WEST SUSSEX COUNTY COUNCIL CONSULTATION

TO:	Arun District Council FAO: Mr A Wood
FROM:	WSCC - Highways Authority
DATE:	23 April 2020
LOCATION:	Land Adjacent Station Cottages, Ford Road, Ford, BN18 0BH
SUBJECT:	F/2/20/PL Change the use of 1/2 the site area to a hard standing storage area (resubmission following F/9/19/PL).
DATE OF SITE VISIT:	n/a
RECOMMENDATION:	More Information
S106 CONTRIBUTION TOTAL:	n/a

Proposed Fence and earth mound elevation

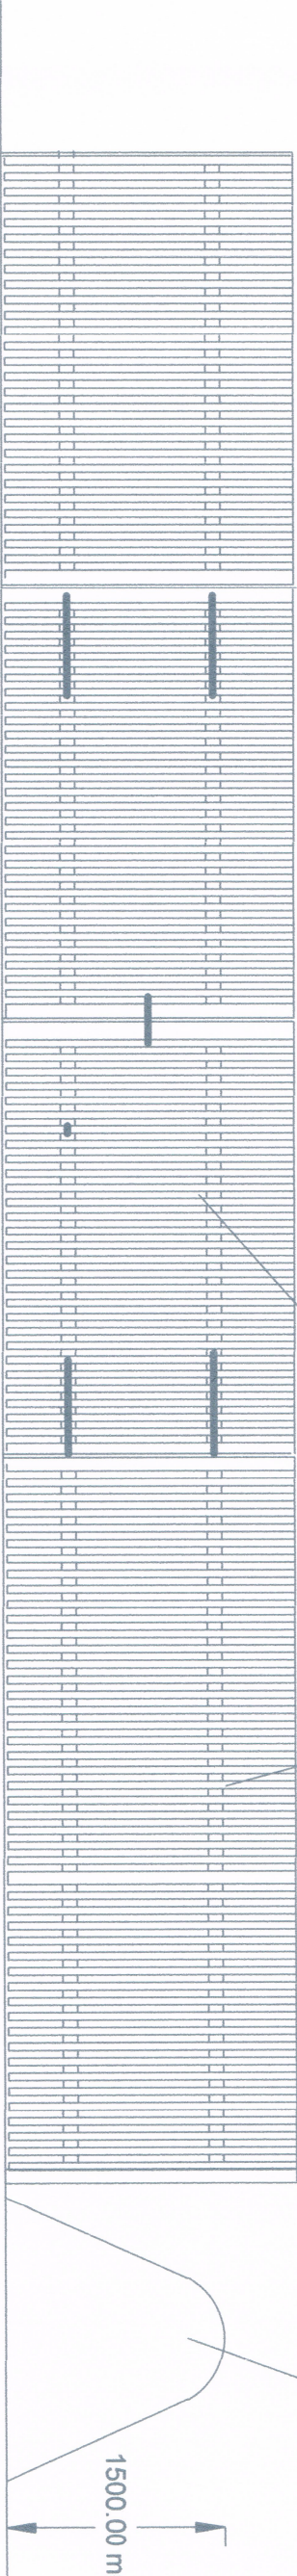
The applicant proposes to erect a fence along the site boundary. The provided elevation plans do not indicate the height of the proposed fence, although from comparison to the proposed mound, this will be greater in height than 1.5m. The proposed fence appears to follow the site boundary and does not appear to encroach on highway boundary land. However, the applicant should be aware that the proposed fence positioned to the north of the site, abutting the edge of the junction with Ford Road, must not encroach upon highway land and must not obstruct any proposed visibility splays. The applicant should also take this proposed fence into consideration when demonstrating swept path tracking for vehicles entering and exiting the site.

Proposed entrance and hard standing
alteration with change of use

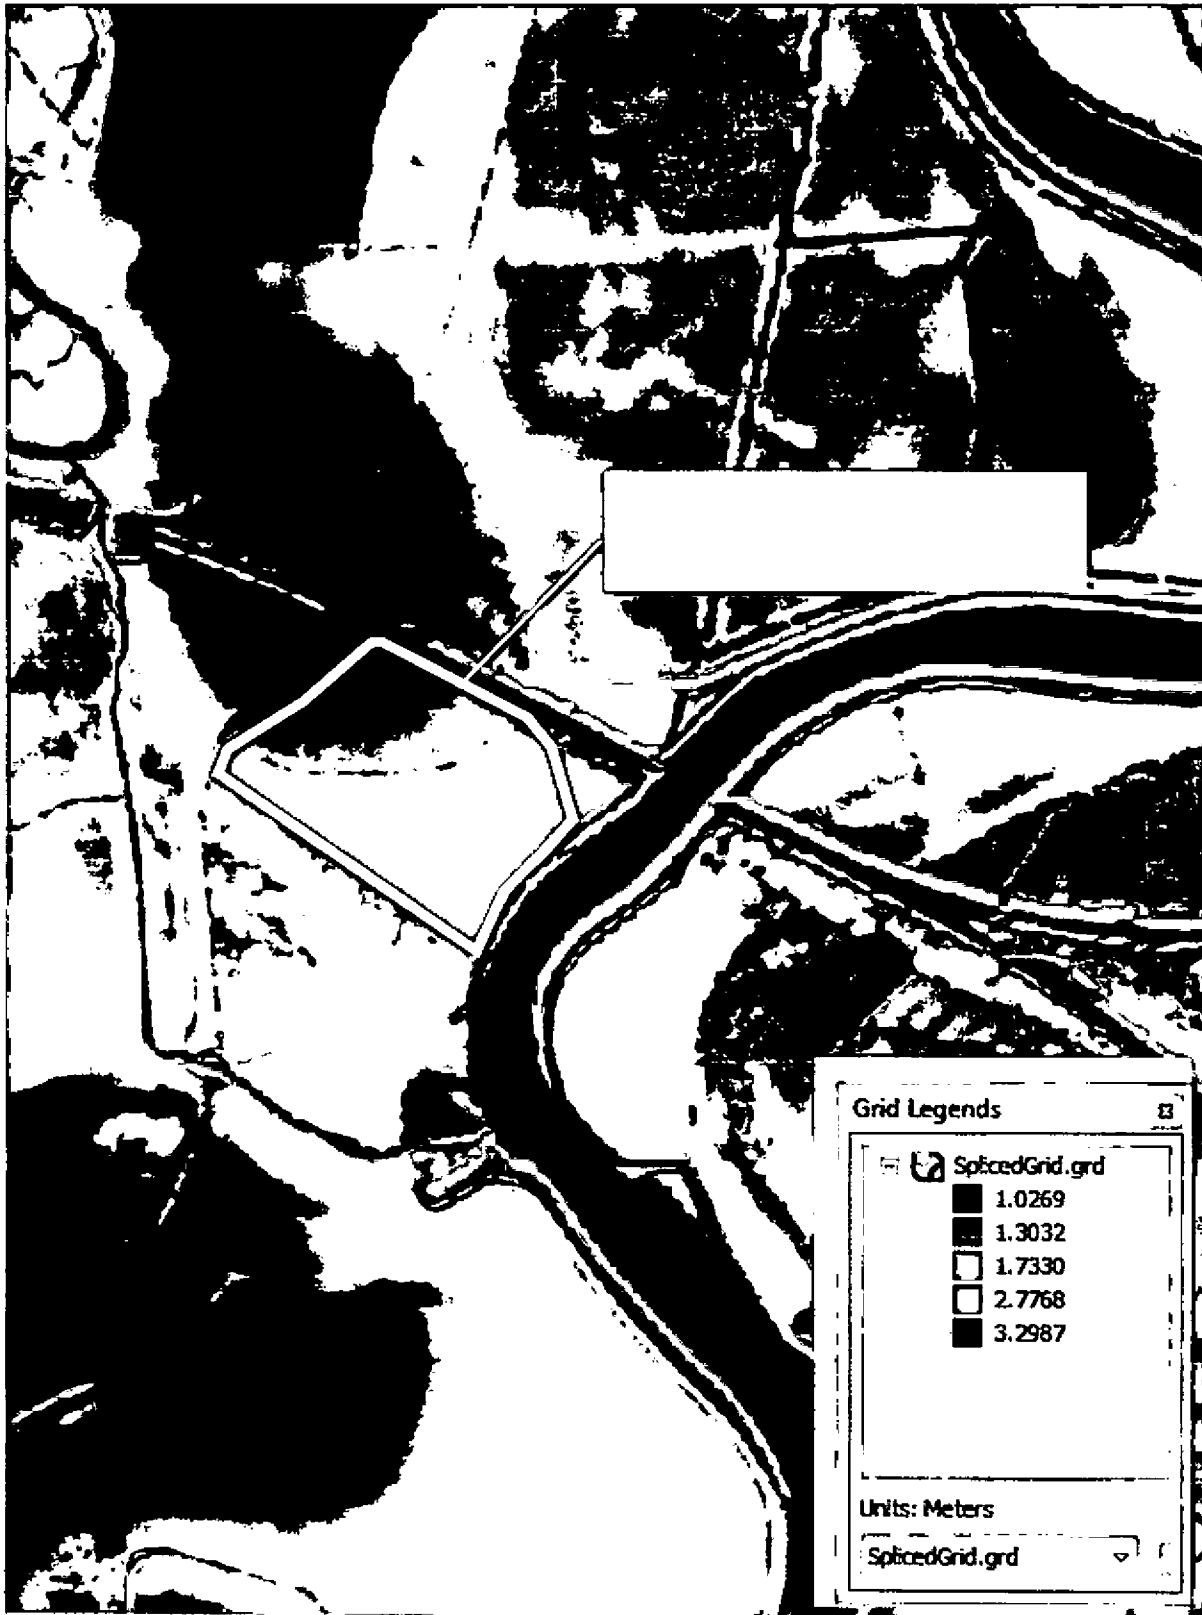
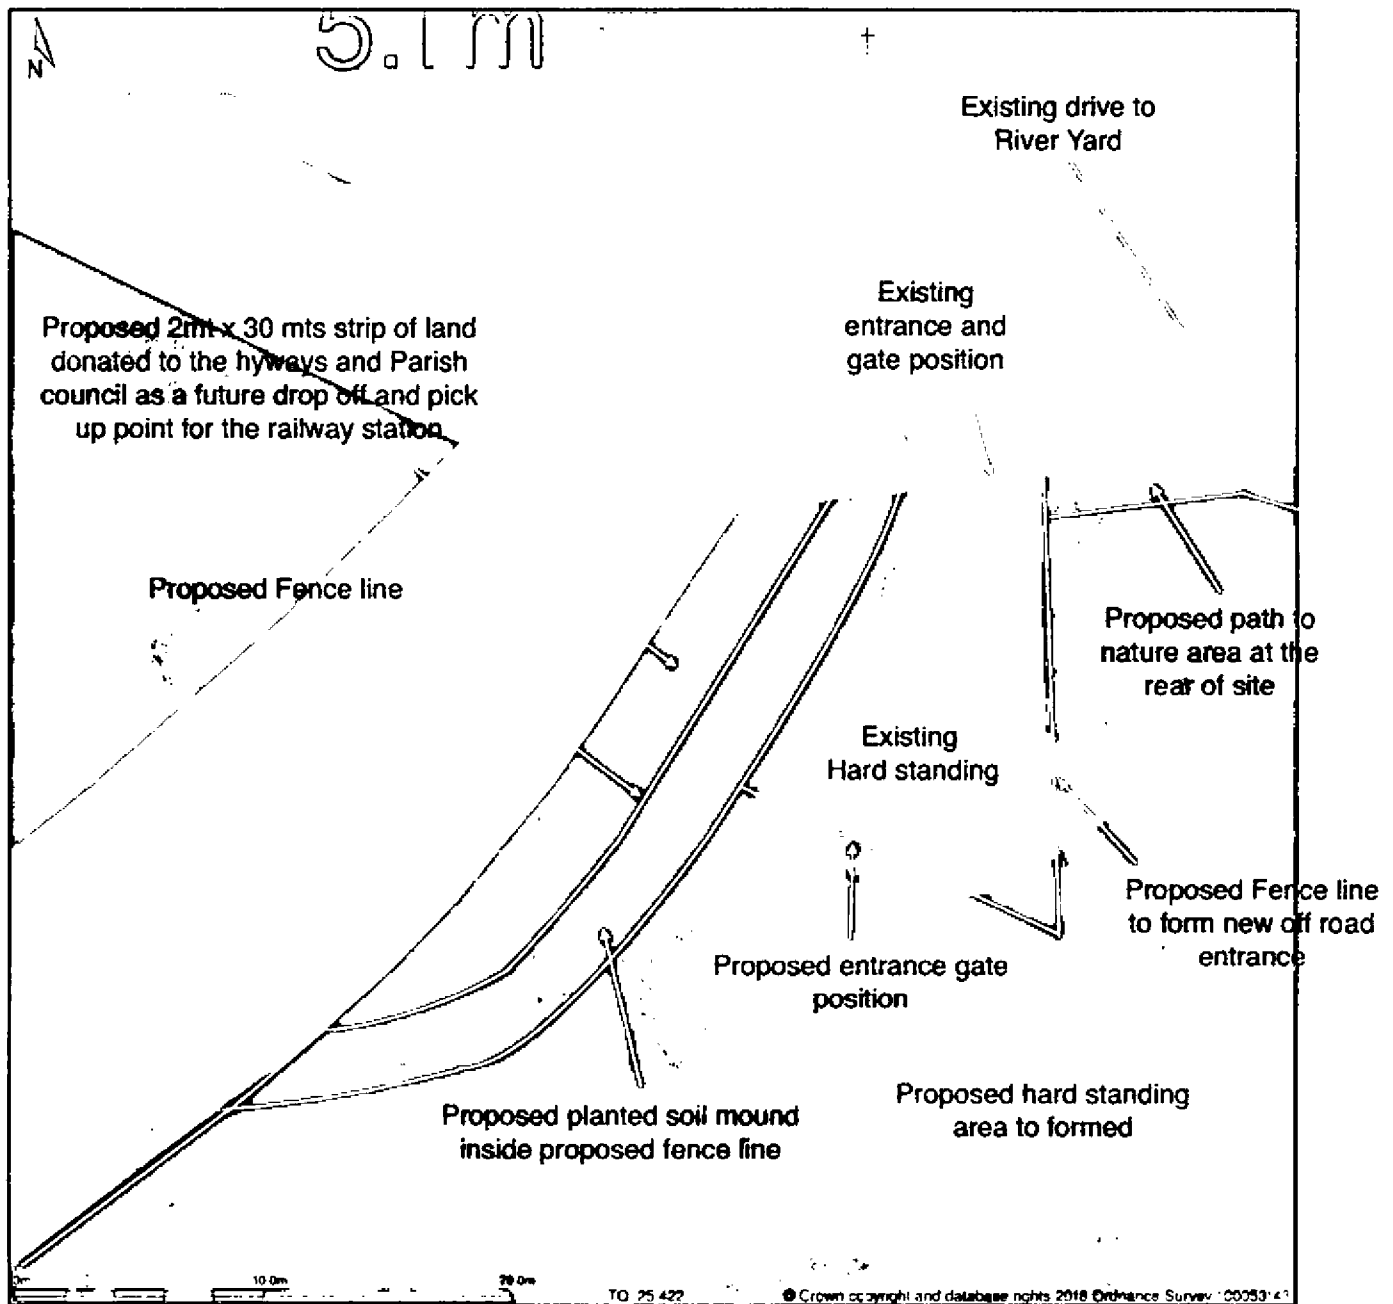
The existing site access exits onto the junction of the existing private access with Ford Road. The applicant does not propose to alter the existing access width of the private access way.

The applicant has not provided visibility splays to support the intensification of use of the site. As Ford Road is subject to a speed limit of 40mph, Design Manual for Roads and Bridges (DMRB) TD9/93 is the appropriate standard in this location. This sets out a Stopping Sight Distance of 120m in each direction. Splays should be drawn from a distance of 2.4m back into the access to the nearside edge of the carriageway in each direction, or at an offset of 1m to represent the track of a vehicle. The splays should utilise land only within the control of the applicant, or within the highway boundary.

The applicant has outlined that the storage use will include the storage of boats and caravans. The applicant is requested to demonstrate via swept path tracking that vehicles can enter and exit onto the public highway in each direction. It is noted that this access has the potential to be used for agricultural vehicles currently due to the existing agricultural use, however this is anticipated to be a less frequent use than that proposed.

The applicant is requested to provide a site layout plan indicating the location of proposed metal containers and any other buildings or structures on the site. A proposed parking layout plan should also be provided and details should be provided demonstrating that vehicles, including the largest anticipated vehicle, can turn on site and exit onto the public highway in a forward gear.
